NORTH FALLS

Applicant's Response to Natural England's Deadline 8 submissions

Document Reference:	9.120
Volume:	9
Date:	July 2025
Revision:	0

Project Reference: EN010119

Figure 2.1 Total sediment deposition thickness during export cable levelling operations in the Annex I Sandbank feature of the SAC

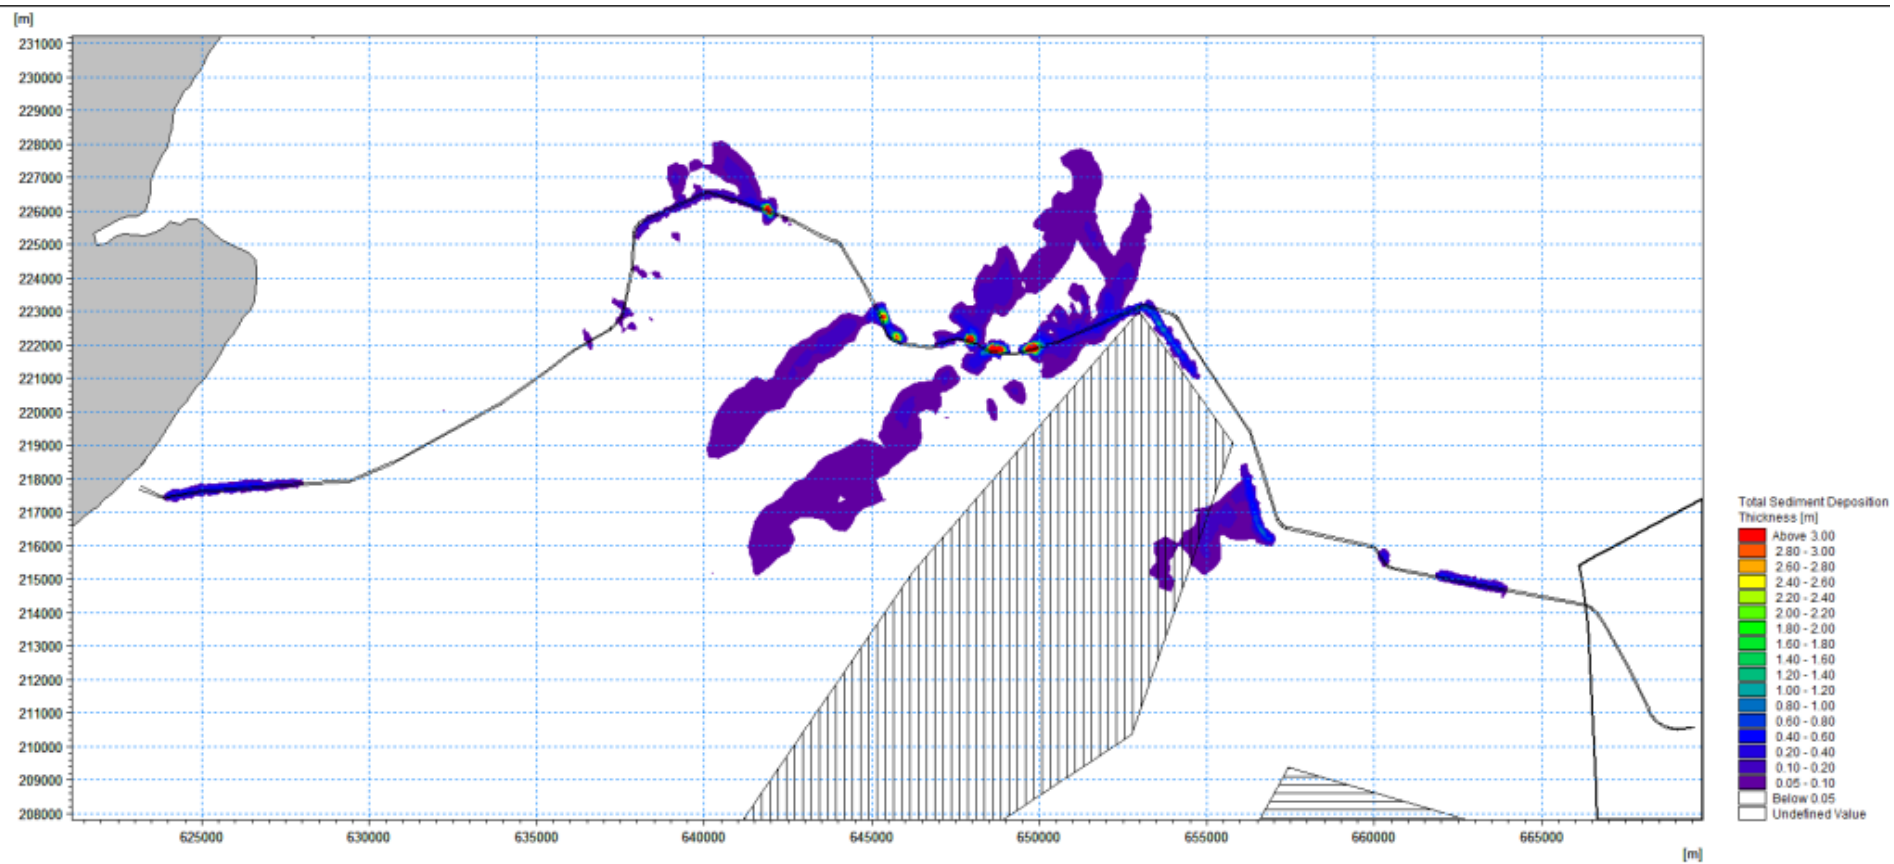
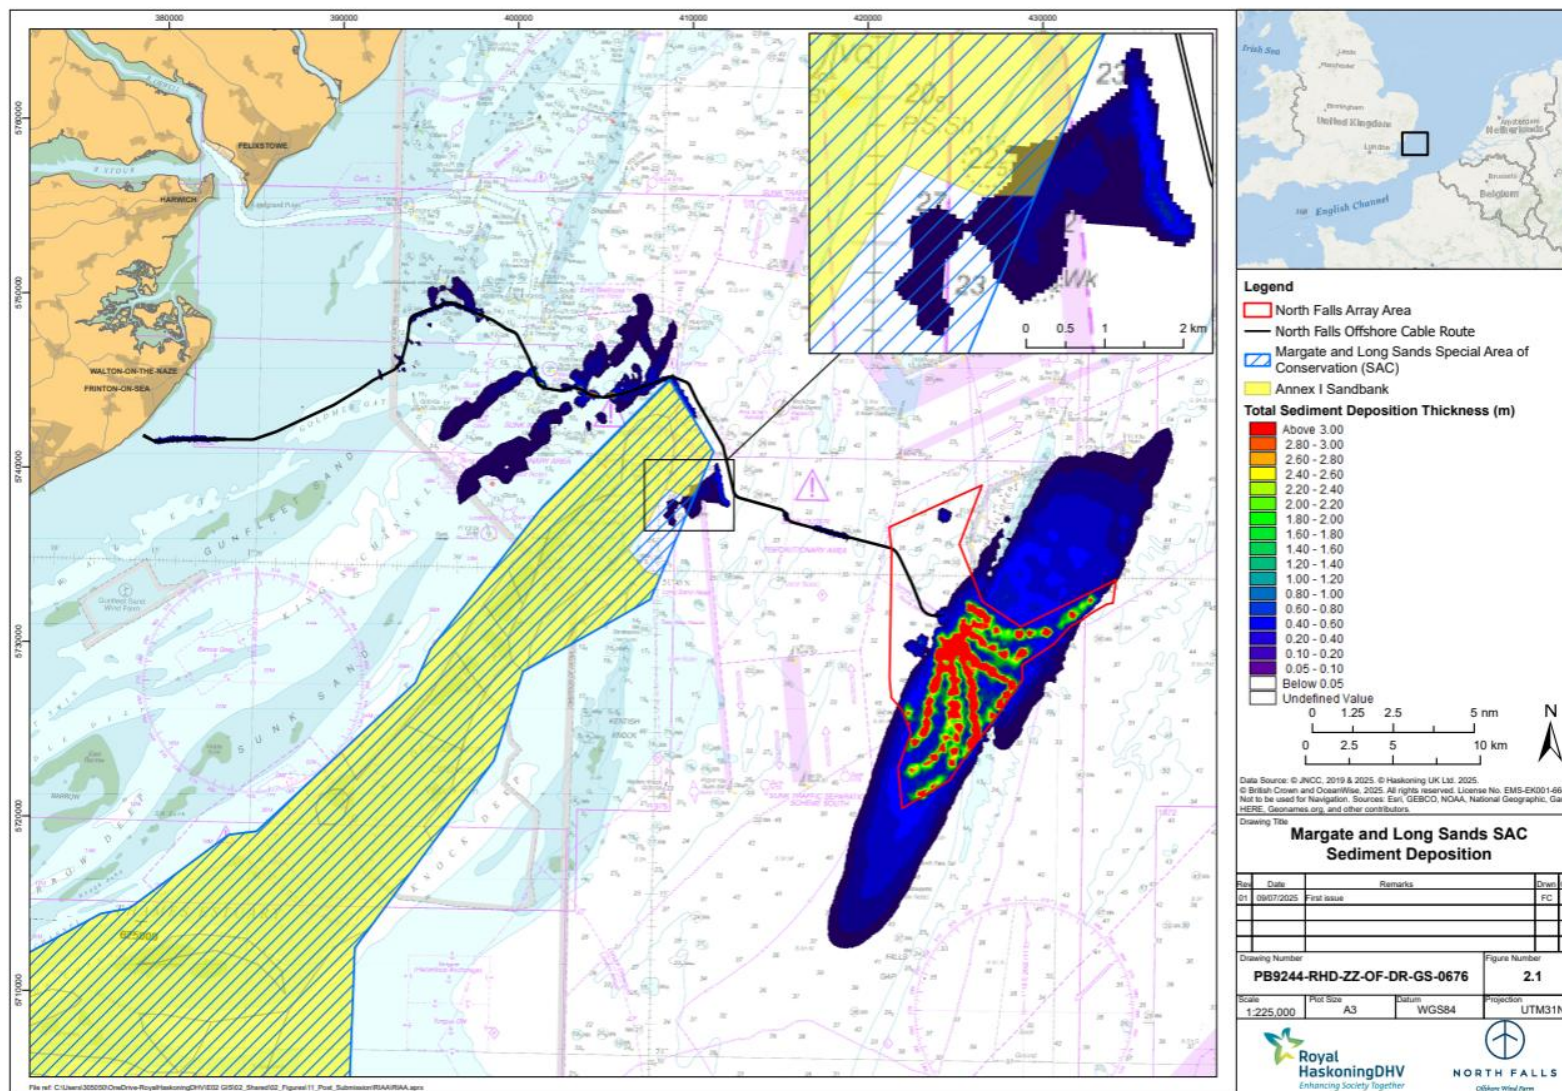
APPLICANT REF	SECTION	NATURAL ENGLAND’S COMMENTS	APPLICANT’S RESPONSE
D8.1	RIAA Paragraphs 50 to 60, Hydrodynamic and Sediment Dispersion Modelling Report, Document Reference 9.54, Rev 2 [REP7-042] Figure 7-12	Natural England is concerned that contradictory information has been presented between the Hydrodynamic and Sediment Dispersion Modelling Report, and the RIAA Part 2. Natural England notes that within the RIAA “Deposition of SSCs arising from the above works could result in 5cm to 15cm sediment depth in an area of c. 1.5km2 (0.23% of the SAC) overlapping the MLS SAC, as shown by the sediment dispersion modelling (Hydrodynamic and Sediment Dispersion Modelling Report, Document Reference 9.54, Rev 02).” However, within the modelling report it is stated that “Figure 7-12 shows the total sediment deposition thickness greater than 5cm which occurs during export cable trenching activities. All sediment deposition occurs within the export cable corridor and is <5cm	Where the RIAA refers to “ <i>Deposition of SSCs arising from the above works could result in 5cm to 15cm sediment depth in an area of c. 1.5km2 (0.23% of the SAC) overlapping the MLS SAC, as shown by the sediment dispersion modelling (Hydrodynamic and Sediment Dispersion Modelling Report, Document Reference 9.54, Rev 02).</i> ” This is based on the worst case scenario for seabed preparation, including sandwave levelling. Trenching is a separate activity from seabed preparation. The information Natural England quotes from the modelling report, is also reflected in paragraph 58 of the RIAA Part 2 [REP7-013] which states “ <i>Changes in seabed level greater than 5cm from seabed trenching for export cable installation are spatially restricted and do not interact with the MLS SAC and will therefore not change the condition of the SAC.</i> ”

We also note that the Applicant’s conclusion that “there is no potential for an AEoI of this attribute due to increased SSC and sediment deposition,” has not been supported with consideration of the ecological implications or sensitivity of the species present. For example, the predicted deposition has not been set in the context of MarESA pressure benchmark thresholds for smothering or considered in light of the specific communities present and their likely sensitivity to the depths of deposition that are predicted. We also refer the Applicant to our small-scale habitat loss policy provided in Annex 1 below.	Ecological implications are assessed throughout the RIAA. For example, page 34 of the RIAA Part 2 [REP7-013] provides the assessment of effects of suspended sediment concentrations, sediment deposition (smothering) and bedload transport on the structure and function of sandbank communities. This assessment considers the ecological implications of the sediment deposition and concludes there will be no AEoI. The Applicant is aware of Natural England’s small-scale habitat loss policy relating to project infrastructure within designated sites, however there is no habitat loss due to the Applicant’s commitment to avoid overlap with the Margate and Long Sands SAC and Kentish Knock East MCZ in response to pre-application consultation with Natural England.
